**KIRKLEES METROPOLITAN COUNCIL  
INVESTMENT & REGENERATION SERVICE**

Reference No:	<b>2023/44/91632/W</b>
Site Address:	land south of, The Lodge and north of Church Lane, Linthwaite, Huddersfield
Description:	Discharge of conditions 16 (ventilation) and 30 (pedestrian routes) of previous permission 2021/91571 for erection of residential development for 125 dwellings
Recommending Officer:	Victor Grayson

## **Second Officer Report**

**Discharge of conditions 16 (ventilation) and 30 (pedestrian routes) of previous permission 2021/91571 for erection of residential development for 125 dwellings**

Client	Yorkshire Housing Casey Construction Ltd
Job	Broadoak Farm Linthwaite
Title	Proposed Footpath Setting Out 1 of 2
Scale	1:250 @ A1
Note - Prints from PDF files may not be to scale, check accuracy against scale	
Job Number	911277
Drawing Number	116
Issue	C6

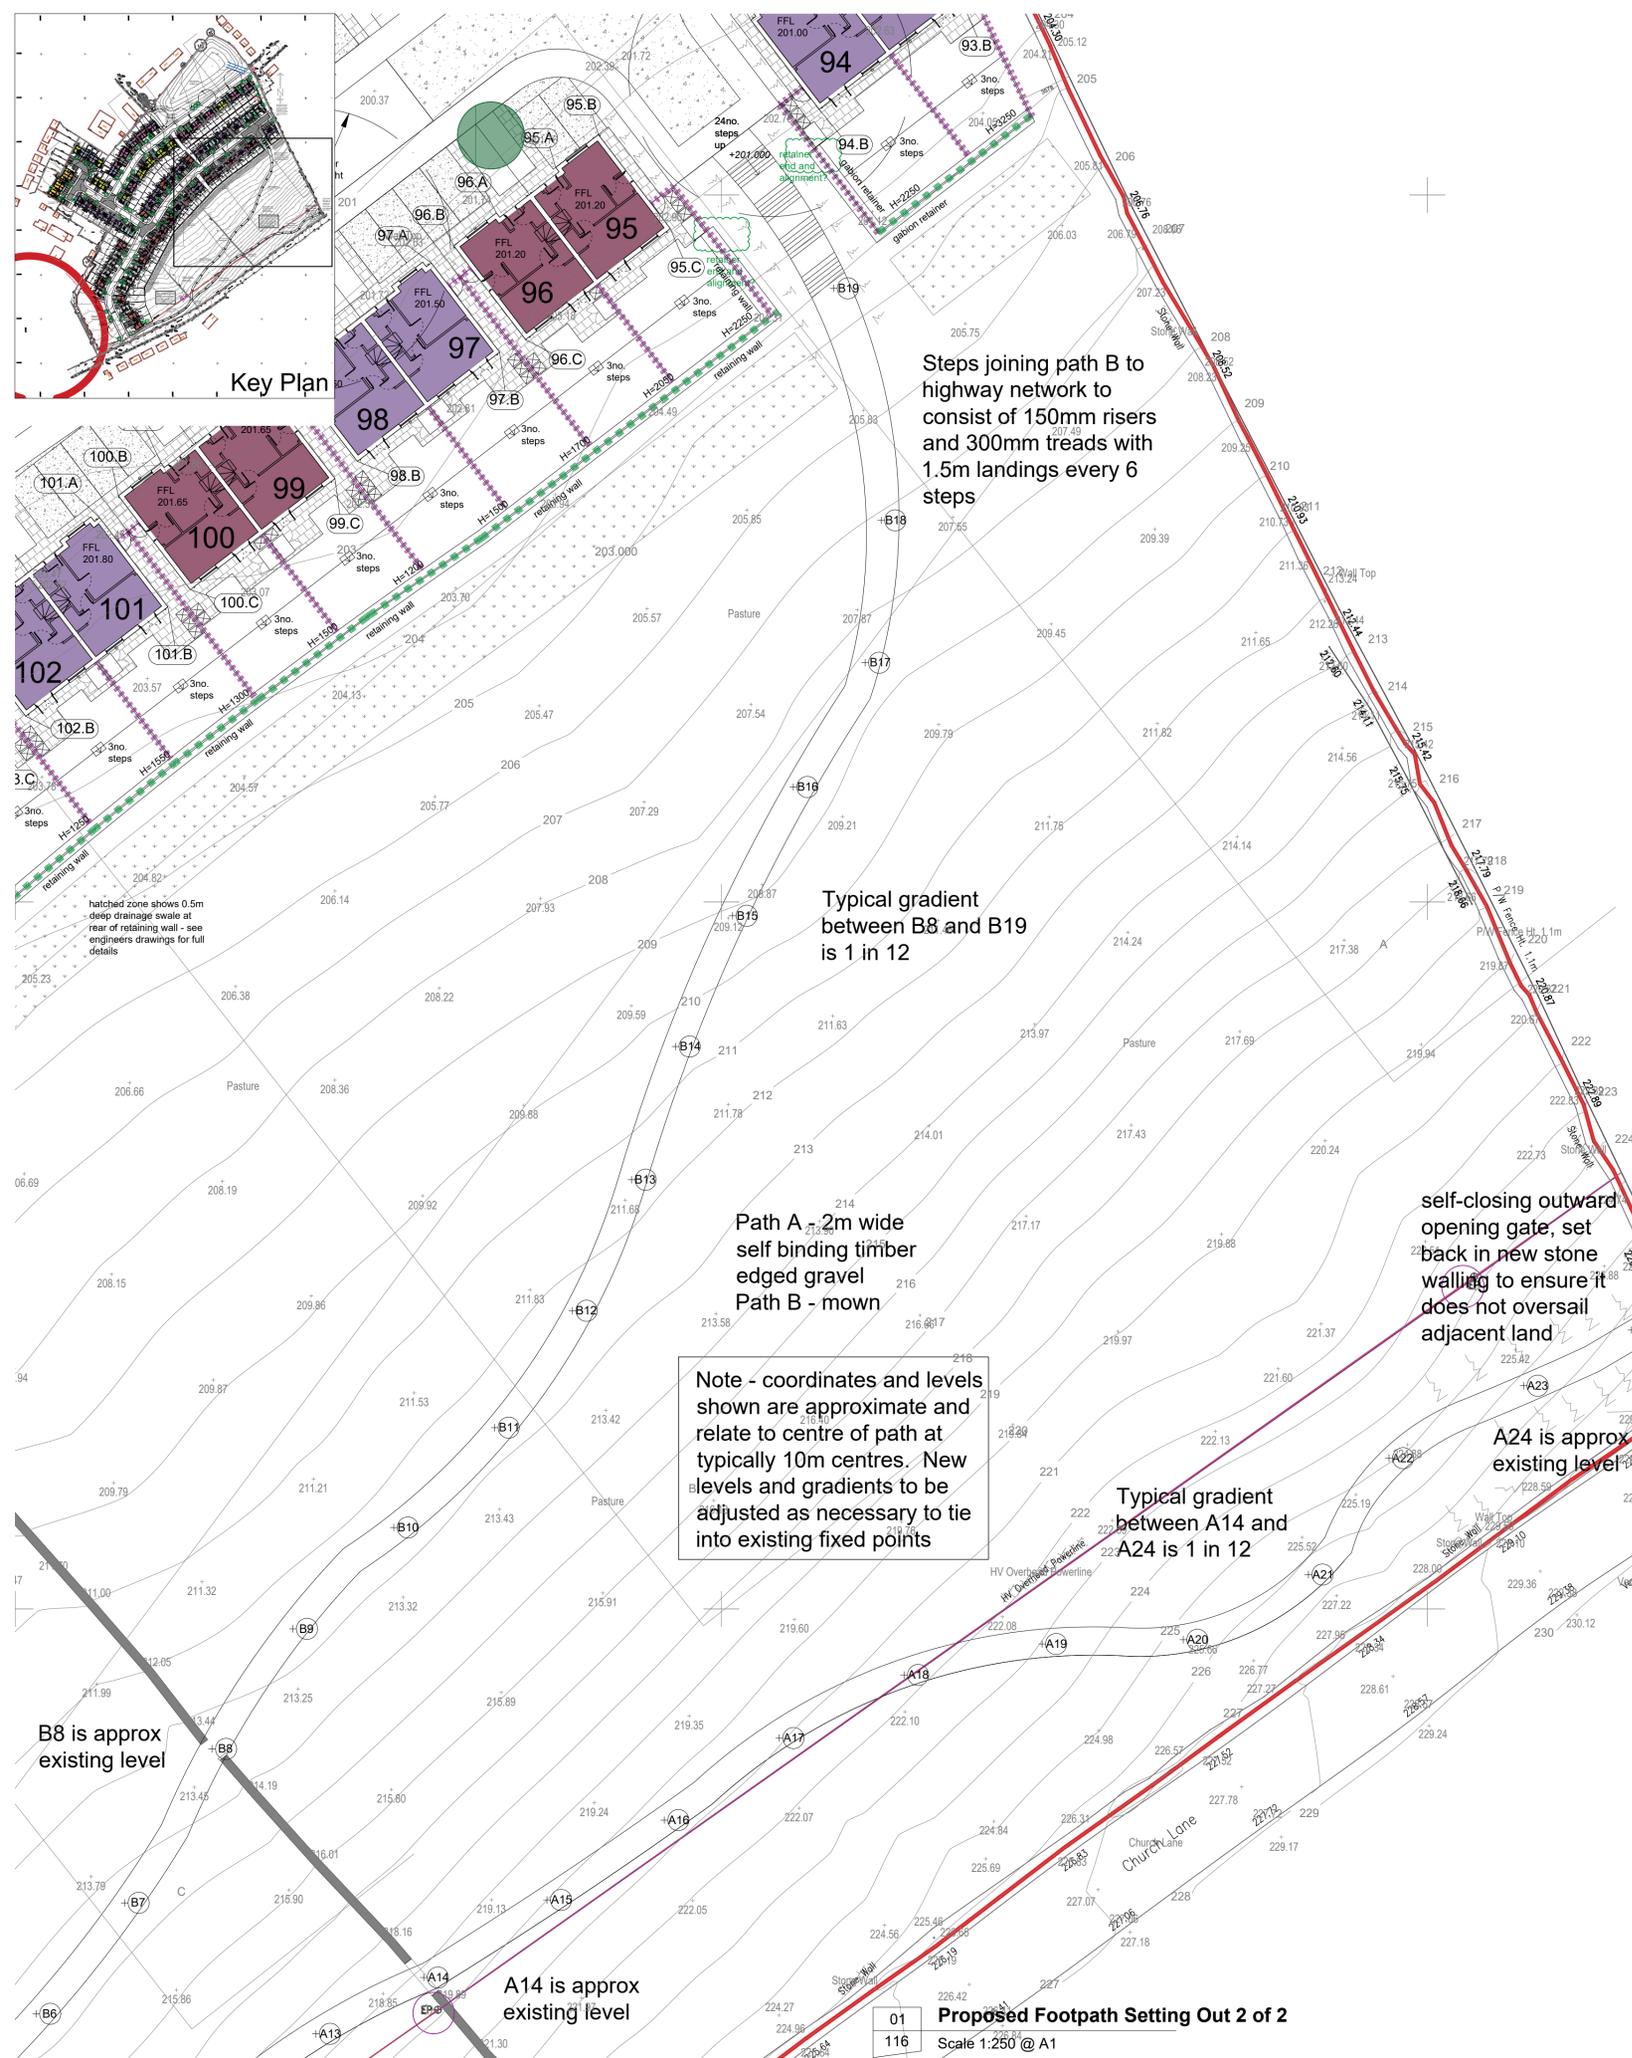
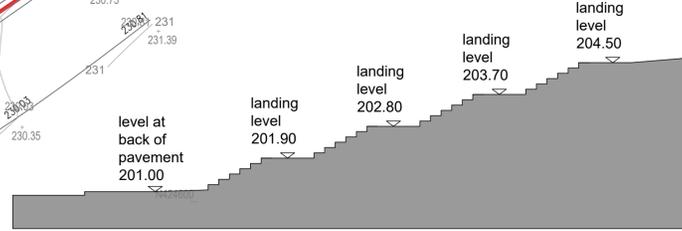
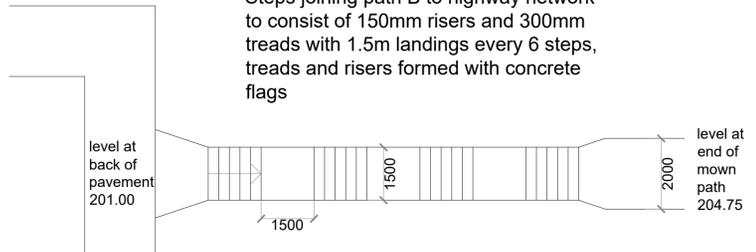
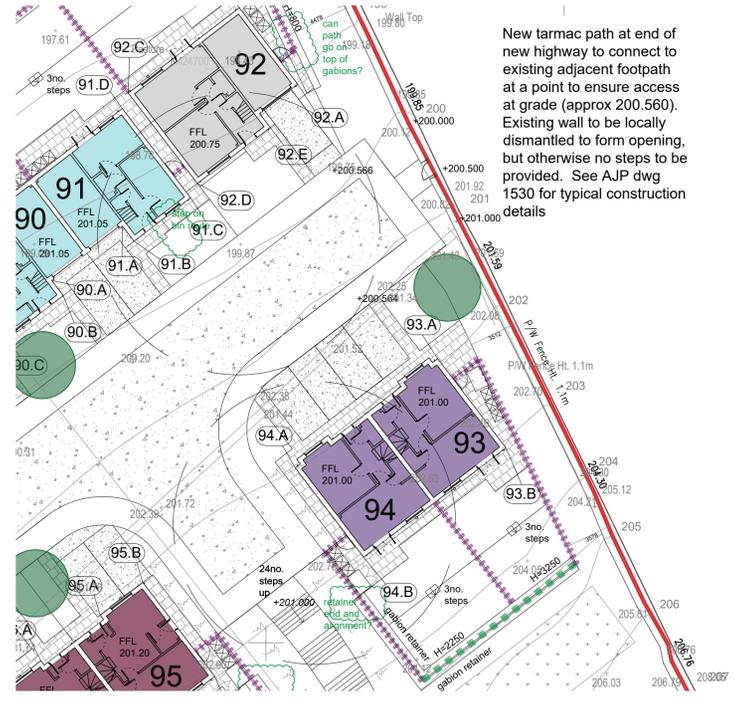
The east-west path has been constructed, and a timber gate has been installed at its east end.

The submitted drawings provide sufficient detail of the construction of this path, and respond to earlier officer advice. The drawings illustrate a timber-edged 2m wide path, surfaced with stone chippings (6mm to 10mm in size) held in place by a Bodpave product. On the uphill side of the path, a drainage channel (with a perforated pipe beneath) is shown. No railing is proposed along this path. New stone walling is proposed either side of the gate at the east end of this path.

Gradients along the east-west path vary due to the site's topography. The applicant's submission refers to gradients typically being between 1:12 and 1:35. Although 1:12 would be steeper than what would normally be considered acceptable (no steeper than 1:20 is the preference), based on site observations it appears the path's steeper parts are short in length.

The proposed gate at the east end of the path is considered acceptable. On 09/05/2024 and 03/06/2024 the applicant confirmed that this would be self-closing (which is considered necessary, to keep out livestock from the adjacent field), and on 06/04/2025 it was noted that the gate was sprung. The gate appears to be of a width and design that would enable people with certain disabilities to use it.

Branching from this east-west footpath would be a second path, leading downhill to the turning head between units 94 and 95 (now 64 and 62 Acorn Rise). As of 06/04/2025, work on the steps at the turning head had commenced.

This secondary path would be mown grass, and would not have a constructed surface. On 06/10/2023 the applicant confirmed that the land either side of the path would be slightly banked in order to define the route. The path's typical gradient would be 1:12 along its eastern section, and 1:20 along its western section.

The 24 steps illustrated at the north end of this secondary path would consist of 150mm risers and 300mm treads with 1.5m landings every six steps.

This secondary path would be steeper in places than preferred. These gradients, and the inclusion of steps at its north end, would limit the secondary path's accessibility to people with certain disabilities and/or limited mobility.

There are also concerns that the proposed mown path could become muddy, and that this could also result in the steps becoming slippery.

Of note, there is only one such "other" connection between the site and public footpath HUD/235/10 – this is at the terminus of Acorn Rise (between units 92 and 93, which are now 57 and 66 Acorn Rise), where a gate (similar to that further uphill, at the east end of the east-west path) has been installed, and where a tarmac surface has been laid. These provide step-free access to the public footpath to the east.

This simple pedestrian connection is suitably accessible and legible, and raises no aesthetic concerns. It meets the relevant requirements of condition 30.

In summary regarding the east-west path and secondary path, although there are shortcomings in what has been constructed to date (and in what is proposed), given the acceptable aspects of the provision (regarding design, drainage, accessibility, management and other planning considerations), given the site's constraints which prevent certain concerns being fully addressed, and given the wording and requirements of condition 30, it is recommended that the relevant submitted details be approved.

Job Number **911277** Drawing Number **115** Issue **C5**

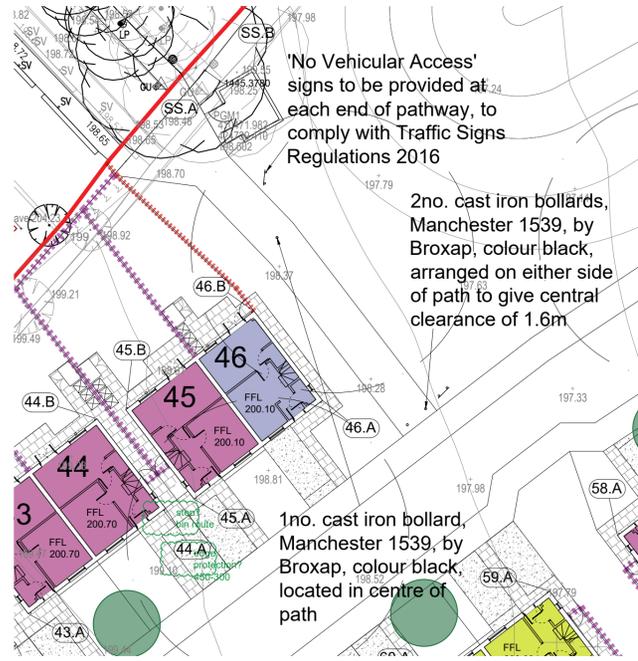
As noted on site on 06/04/2025, this pedestrian connection has already been created, although some works are yet to be completed. The path runs roughly north-south between The Lodge and Holmedale Court, with unit 46 (now 23 Holmedale Court) to the west and an electricity substation and an attenuation basin serving the development to the east. It is surfaced with tarmac, there are two bollards at its southern end, another bollard at a mid-point (approximately) along the path, a dropped kerb and drainage strip at its northern end (where it meets The Lodge), and low timber railings either side of the path. A landscaped strip separates the path from the side elevation of 23 Holmedale Court. A line of sight has been maintained along the full length of the path, so that pedestrians can see the continuation of their route before they decide to use it.

The submitted drawings indicate that an access off the path (to the east) is to be created to enable basin maintenance, that the bollards are cast iron and are the “Manchester” model by Broxap, and that “No Vehicular Access” signs are to be provided at each end of path (and that this signage would comply with Traffic Signs Regulations 2016).

In early 2024, following the opening of the path (but before a temporary concrete block and subsequent bollards were installed), complaints were received regarding drivers using the pedestrian connection to cut through between The Lodge and Holmedale Court. This pedestrian connection was never intended to take vehicular through-traffic. The relevant statutory undertaker will need to be able to access the electricity substation, however this does not mean a through-route (for vehicles) is needed, as the substation can be accessed from the northern (The Lodge) end of the pedestrian connection, where an appropriate dropped kerb has been provided. The subsequently-installed bollards and timber railings, and the proposed signage, will ensure this path is not misused by drivers in the future.

It is understood that this path is to be adopted by the council as Local Highway Authority. Details of the construction and surfacing of the path have been secured as part of Section 38 discussions. The installed bollards are among the models preferred by the council’s Section 38 team.

and useful pedestrian connection), and on what is shown on the two submitted drawings, it is recommended that an approval be issued.
